Doc no. DOC19/593791
File no. SF19/76662

**RE: Response to Response to Submissions (RTS) of Sydney Opera House (SOH)
Building Renewal Program – Concert Hall Upgrade and new Creative Learning Centre
(SSD 8663)**

ATTACHMENT A: SYDNEY OPERA HOUSE BUILDING RENEWAL PROGRAM
CONCERT HALL & CREATIVE LEARNING CENTRE HERITAGE RESPONSE TO
SUBMISSIONS RESPONSE

1
DETAIL SECTION 1- EAST PASSAGEWAY L2.EP.01
1 : 50

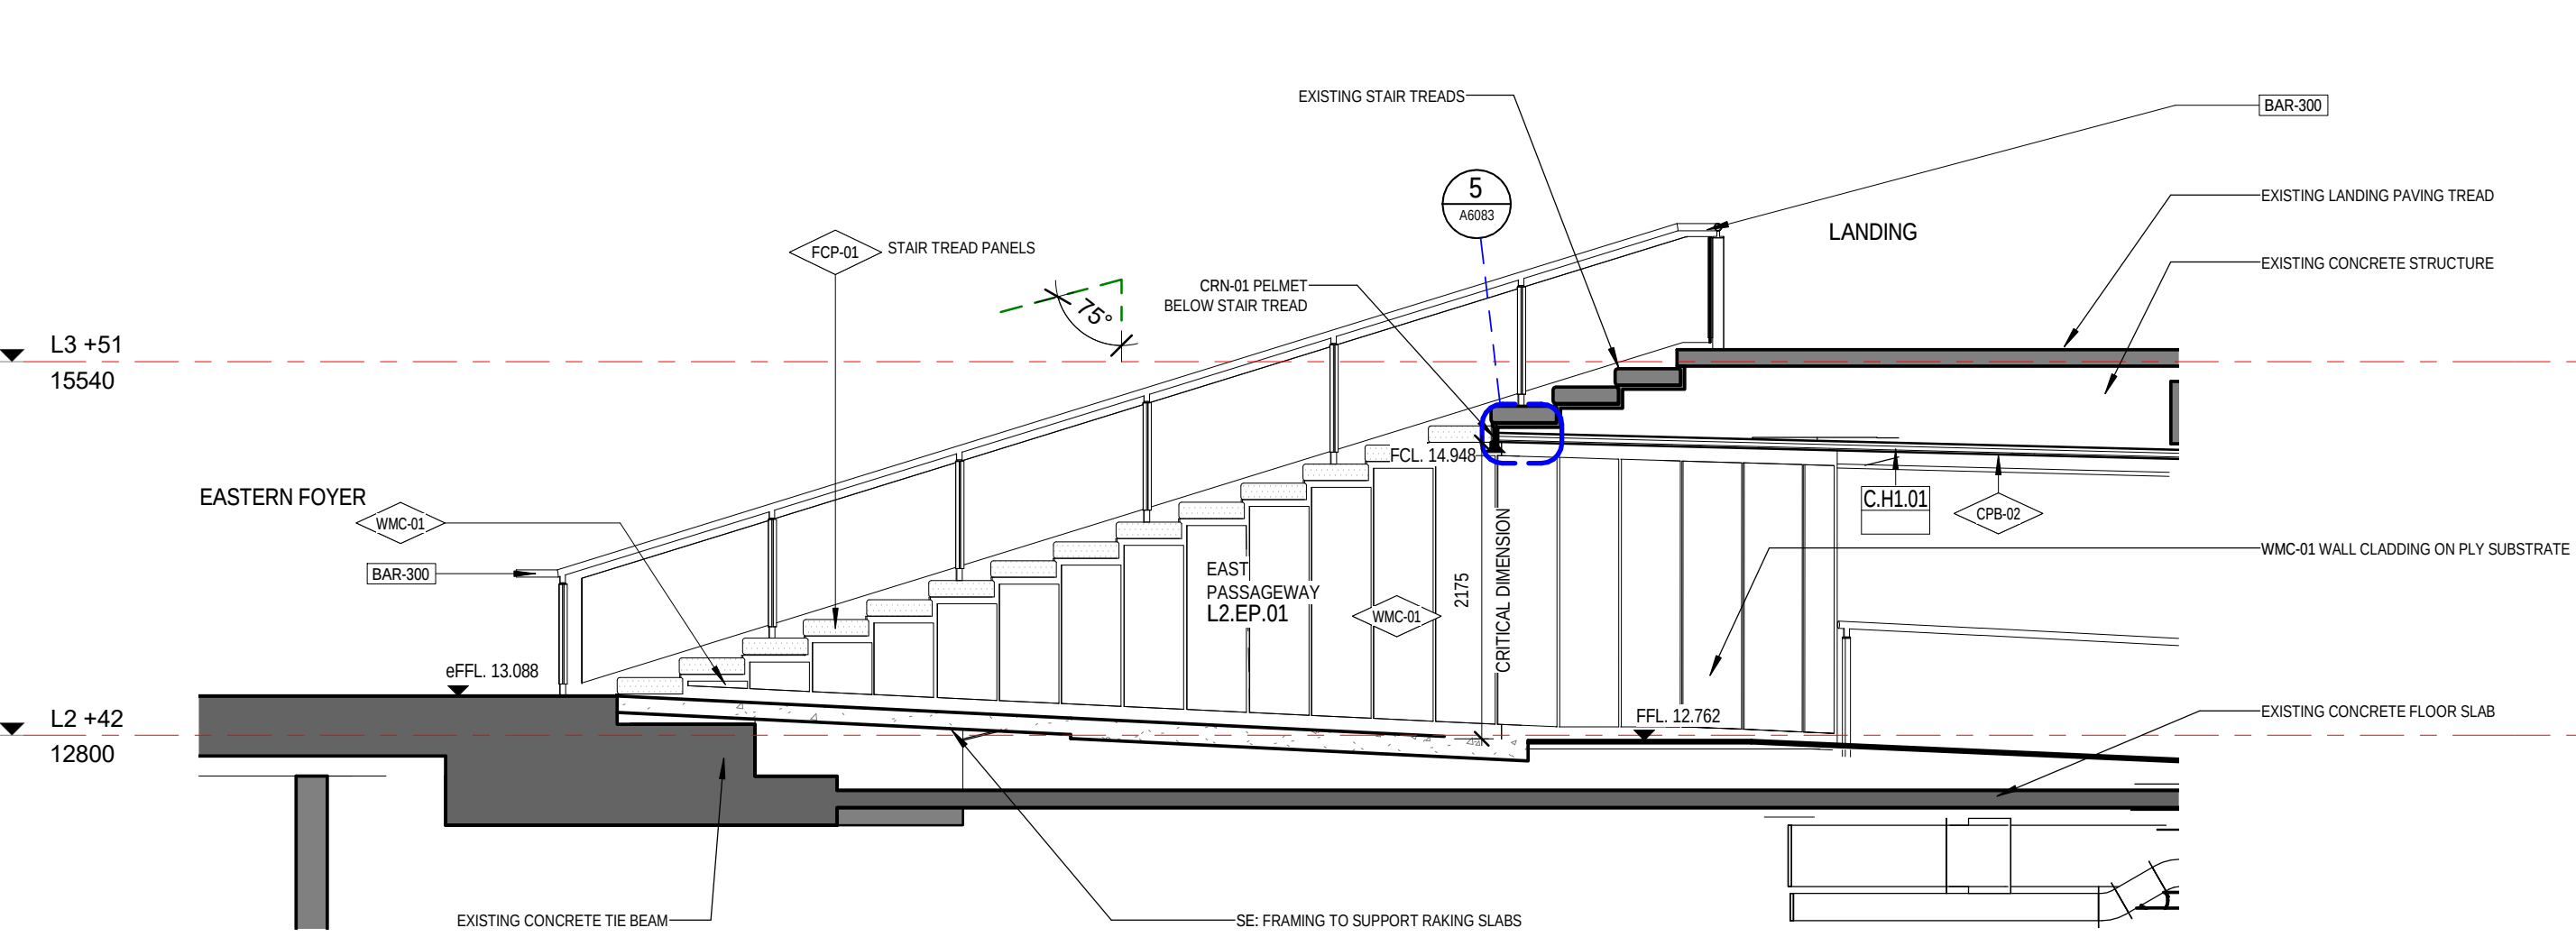
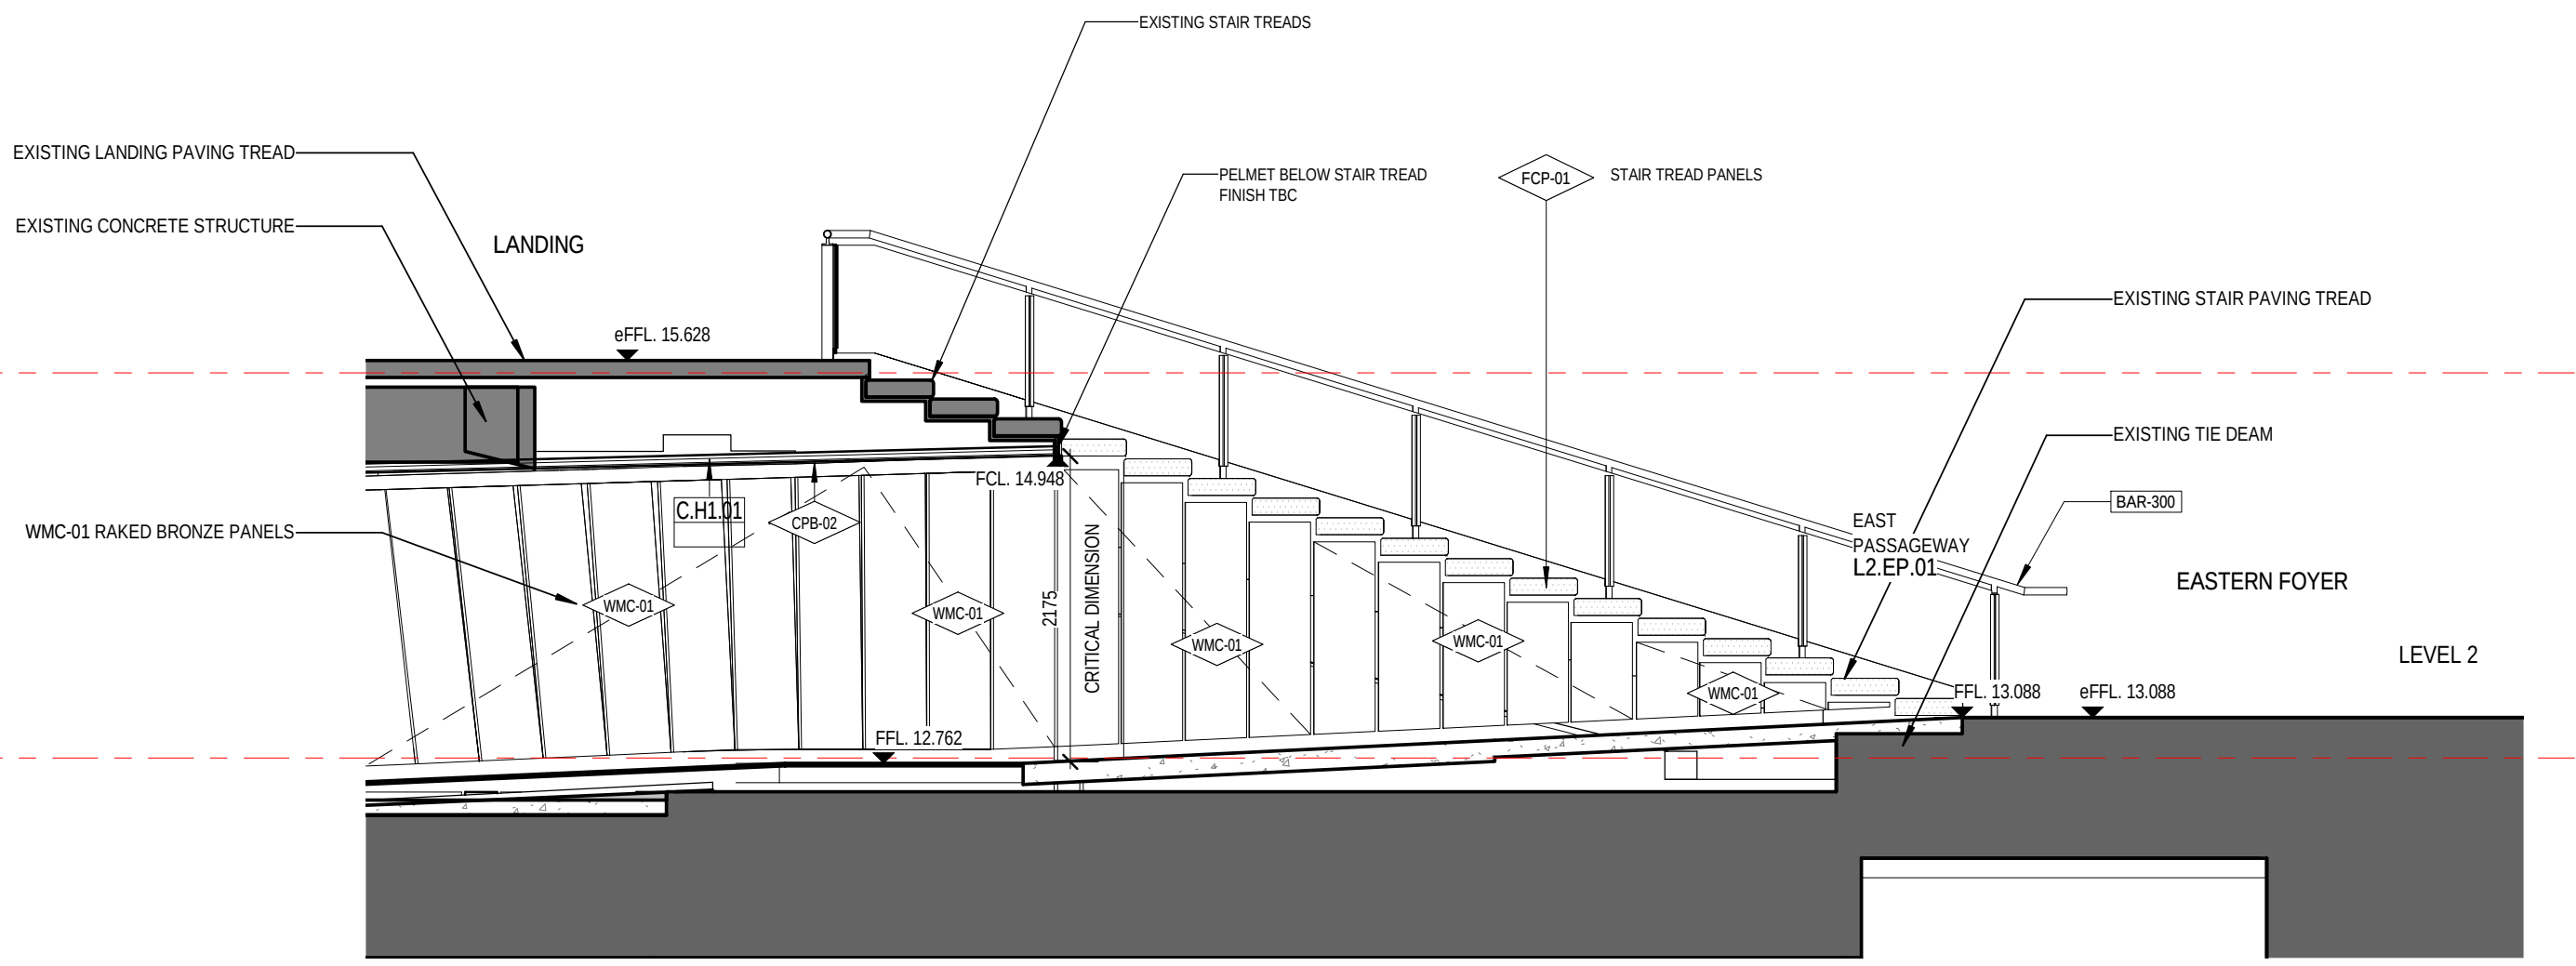
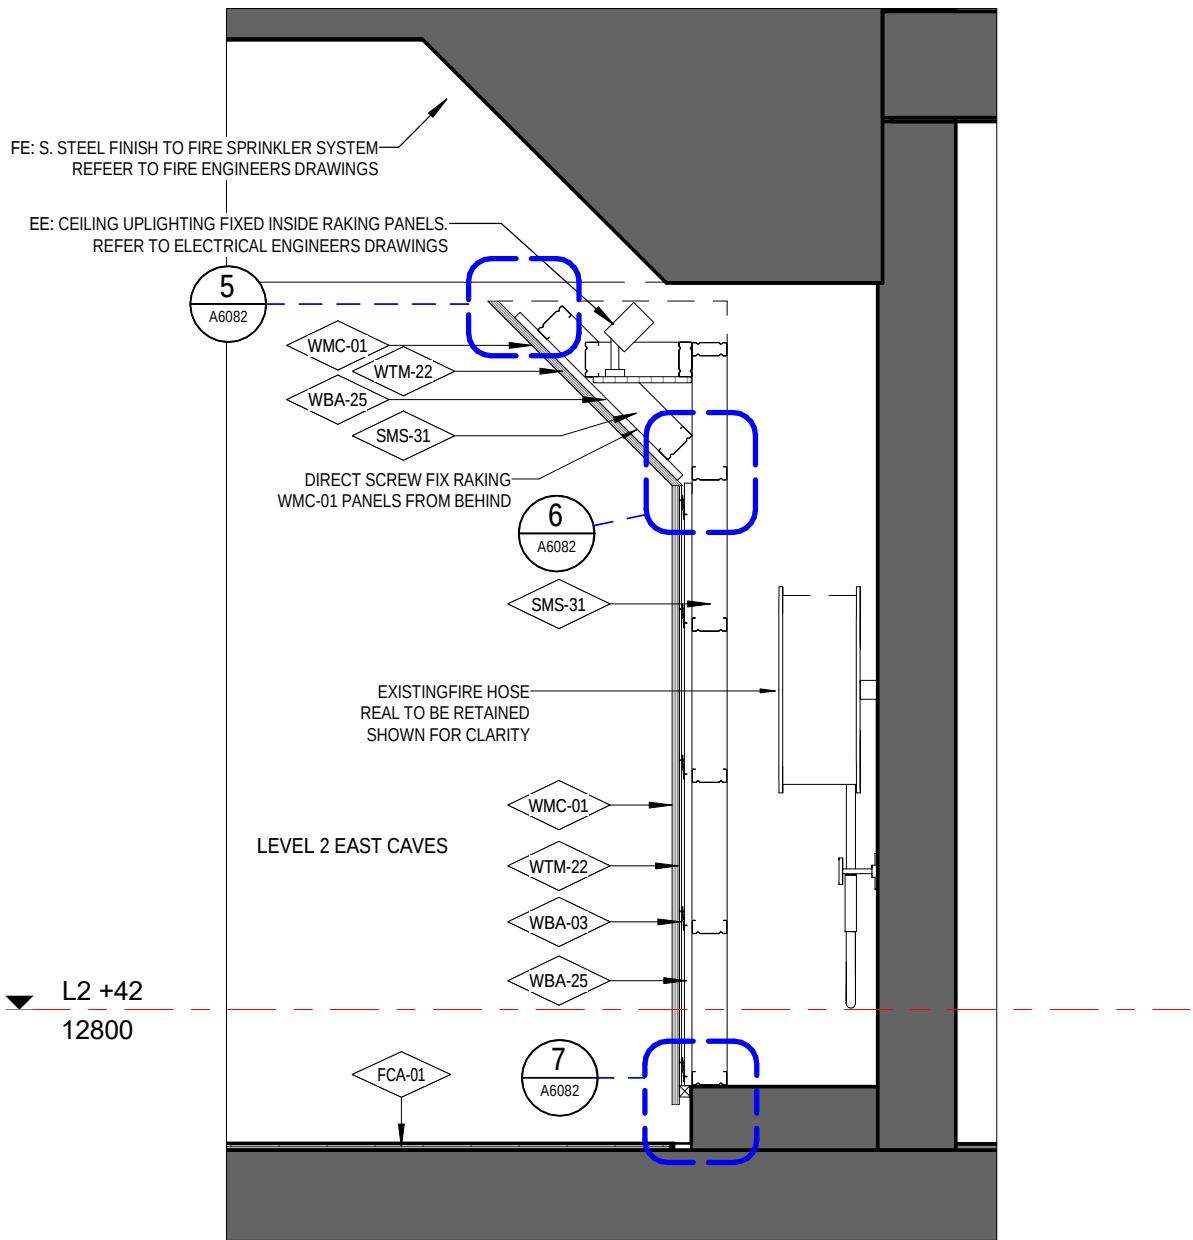
- 2.3 It is still considered that the proposed eastern passageway works will have an adverse impact on significant form, fabric and structure in this area. It is noted that SOH has agreed with Heritage Council recommendations (20 February 2019) that the works, including to new concrete finishes, will be determined in consultation with the nominated heritage consultant working closely with an experienced precast concrete craftsperson to ensure colour, form, finish, quality and workmanship of the new works are integrated into the design.

- 2.4 The Heritage Council considers that the use of the bronze panelling material for the proposed passageway eastern wall introduces a new wall treatment within the SOH. It recommended further consideration be given to better aligning the material with the consistent palette of materials of the SOH. It is also acknowledged that the SOH has undertaken further consultation with the DAP to reconsider the use of bronze panelling within the passageway in accordance with Heritage Council's

- 2.5 Traditionally bronze has been used within the SOH as an accent material on trims and handrails etc. The proposed use of the material within the passageway represents a new wall treatment within the SOH. Further refinement is required to better integrate the passageway wall with the proposed panelled lift shaft.
- 2.6 It is understood that the SOH will further investigate the use of bronze panelling within the western caves (southern wall) in accordance with HIS recommendations, and that this will be submitted as part of the Section 60 application for the works.

- 2.7 The following condition is included in the HIS, *the use of bronze panelling on the southern wall in the Caves area (Level 2) should be tested and reviewed once the other walls are stripped back, by the Opera House's Conservation Council, Eminent Architects Panel (now DAP) and heritage architect, to determine its appropriateness (Pg104)*. This should also be undertaken in consultation with a representative of the Heritage Council and documentation submitted as part of the section 60 application for the works.
- 2.8 Further refinement of the passageway details should be undertaken to better integrate with the proposed finish to the new lift including skirting. This should be submitted as part of the section 60 application for the works.
